**From:** Emily Morgan <emorgan@marysvillewa.gov>  
**Sent:** Tuesday, November 8, 2022 8:58 AM  
**To:** Luay Joudeh  
**Cc:** Dara Eagle; Chris Holland  
**Subject:** RE: [External!] Re: 2nd Technical Review Comments - Marysville 44th PRD - PA22-024  
**Attachments:** MBA Marysville Exhibit-24x36.pdf

**From:** Emily Morgan <[emorgan@marysvillewa.gov](mailto:emorgan@marysvillewa.gov)>  
**Sent:** Monday, November 7, 2022 3:47:08 PM  
**To:** David Morse <[dmorse@tollbrothers.com](mailto:dmorse@tollbrothers.com)>  
**Cc:** Chris Holland <[CHolland@marysvillewa.gov](mailto:CHolland@marysvillewa.gov)>; Luay Joudeh <[luay.joudeh@drstrong.com](mailto:luay.joudeh@drstrong.com)>; Dara Eagle <[dara.eagle@drstrong.com](mailto:dara.eagle@drstrong.com)>  
**Subject:** 2nd Technical Review Comments - Marysville 44th PRD - PA22-024

LANDSCAPE PLAN

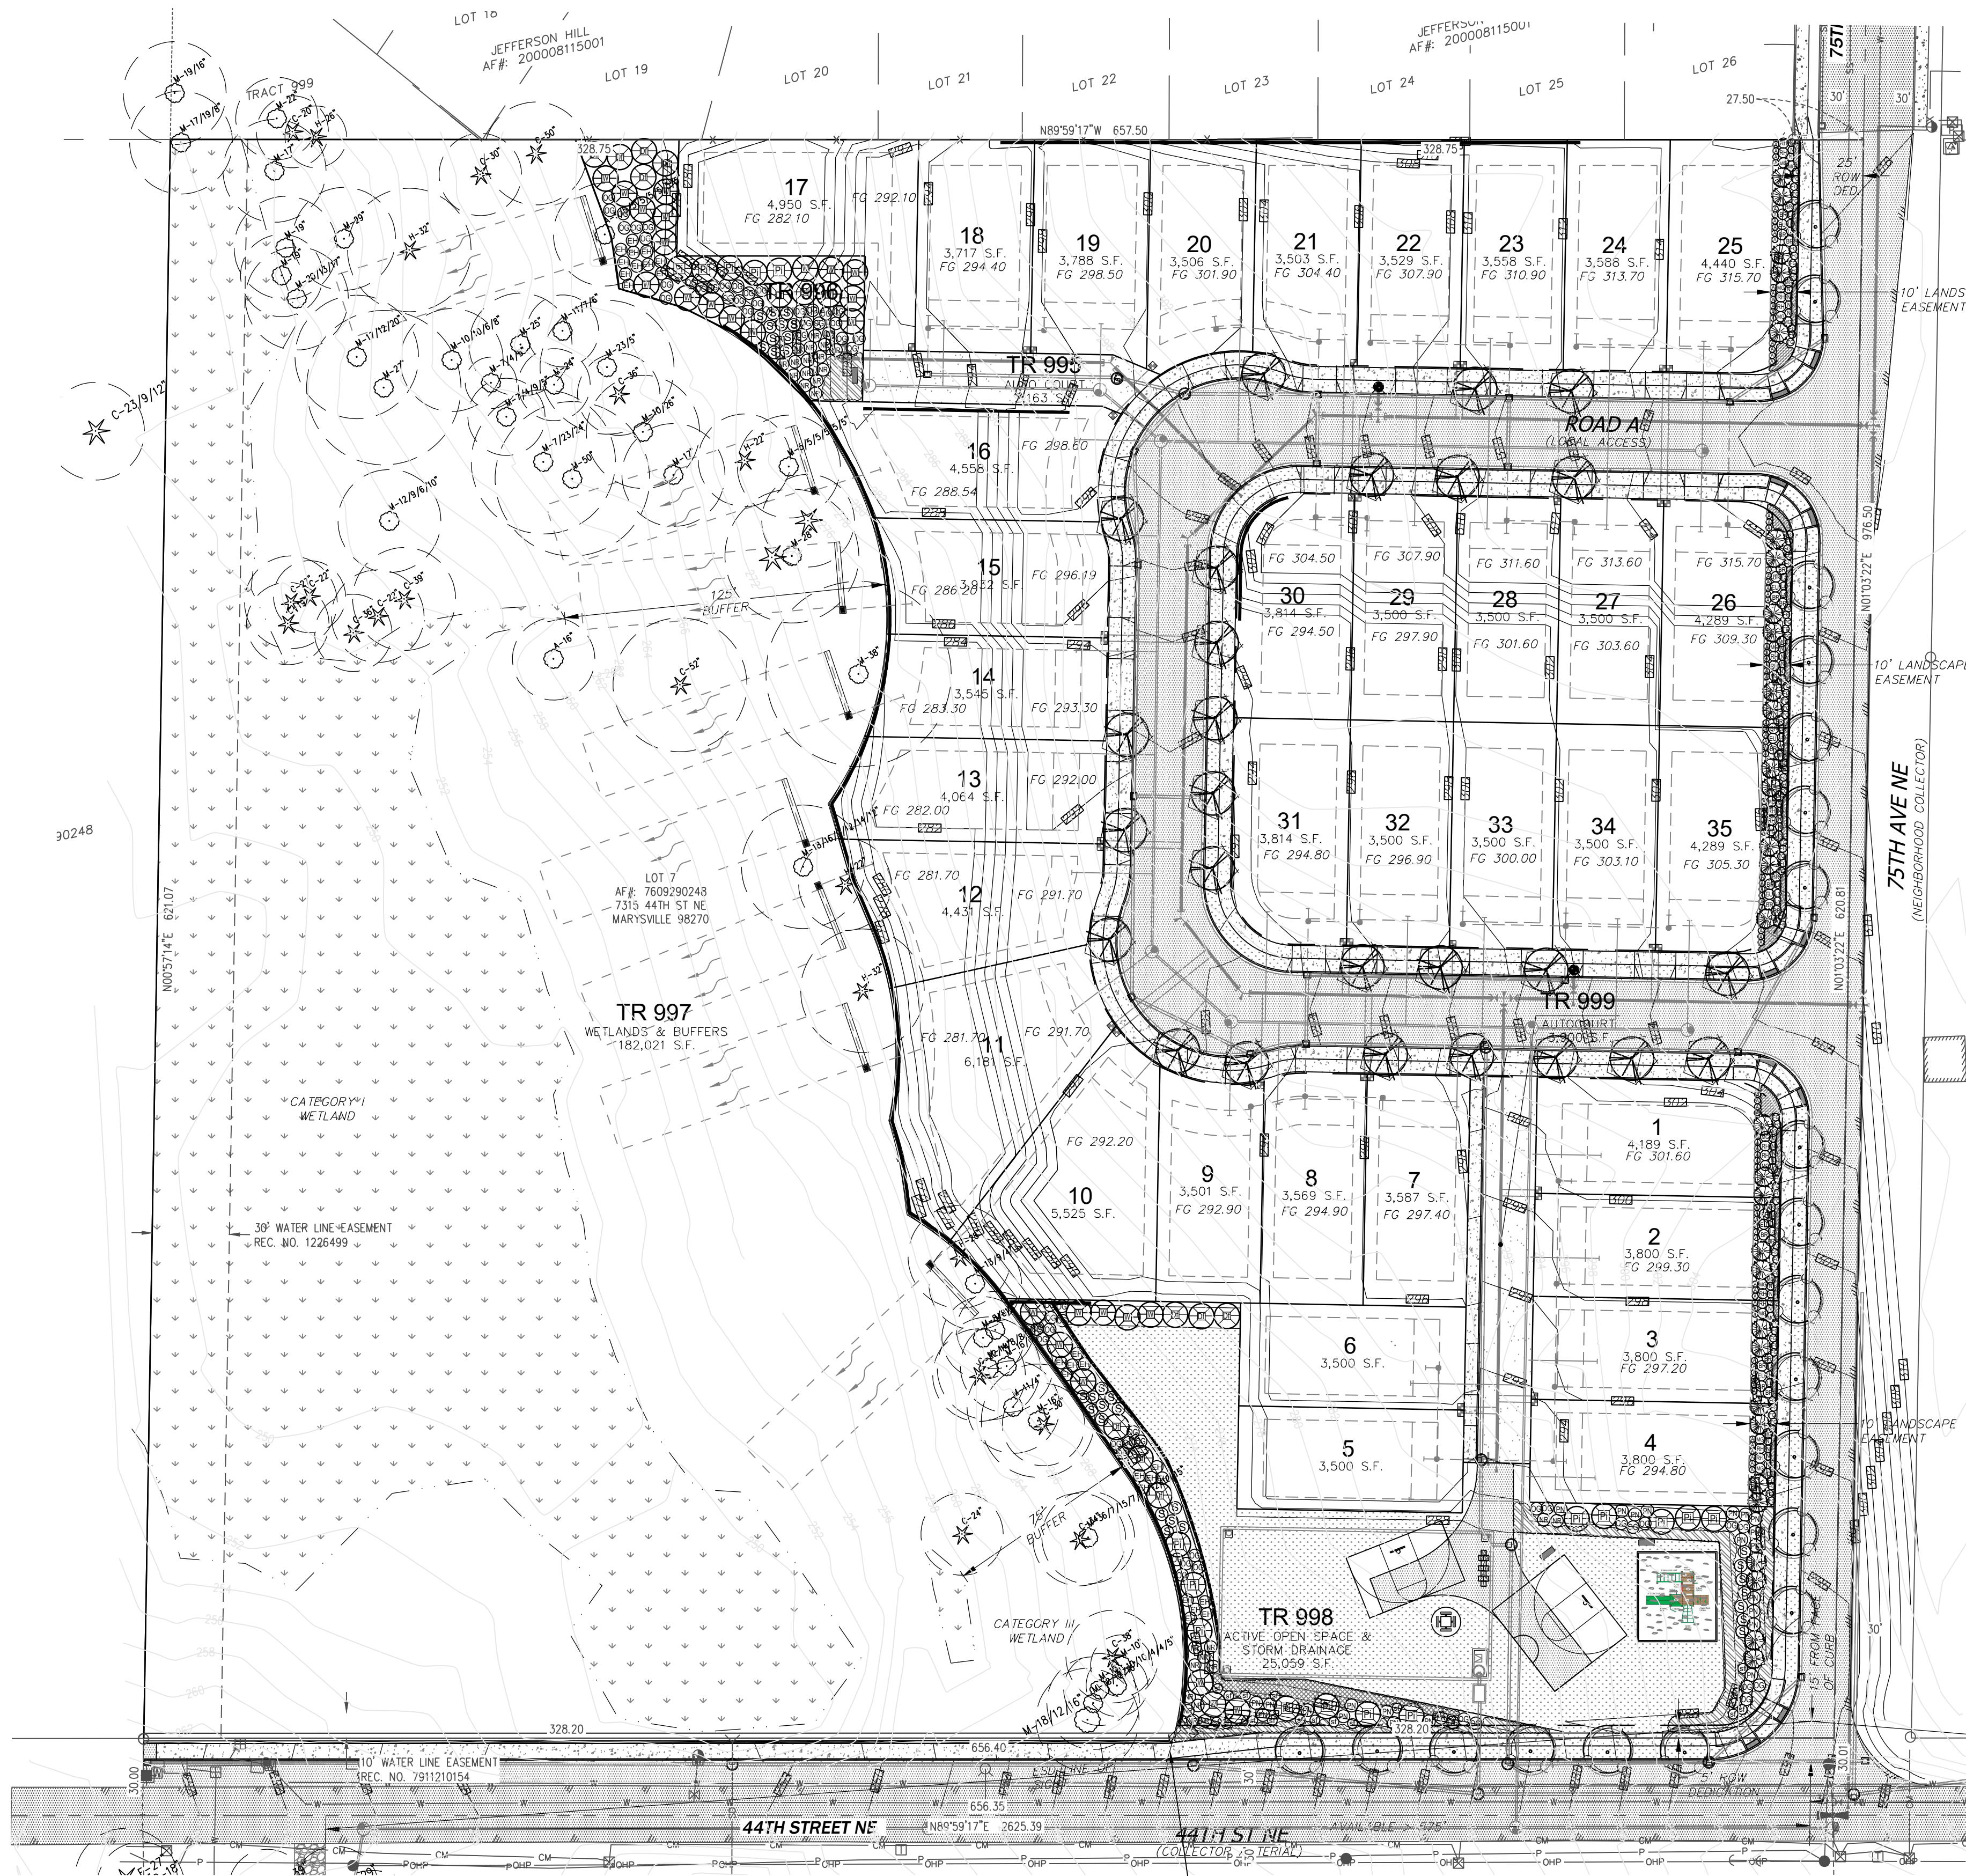
I spoke with Chris to get a little info on what you mentioned below. We are amenable to what you are proposing with the 10 ft. landscaping easement, but it will need to be proposed in a manner that really adds a nice street appeal. I guess there are a couple other projects that have been allowed to go this route and as of now, what they have implemented is not meeting the City's standards for the intent of a classed up street presence.

So to summarize, please be sure to have the landscape architect include something similar to what is attached and include an estate type fencing so it would look nice on both sides of the fence.

Good morning Emily,  
I will send you the email exchange with previous planner regarding access for lots 1-4. We had that discussion early in the project. She suggested we do what city approved for maple wood to the west which was the 10ø easement.
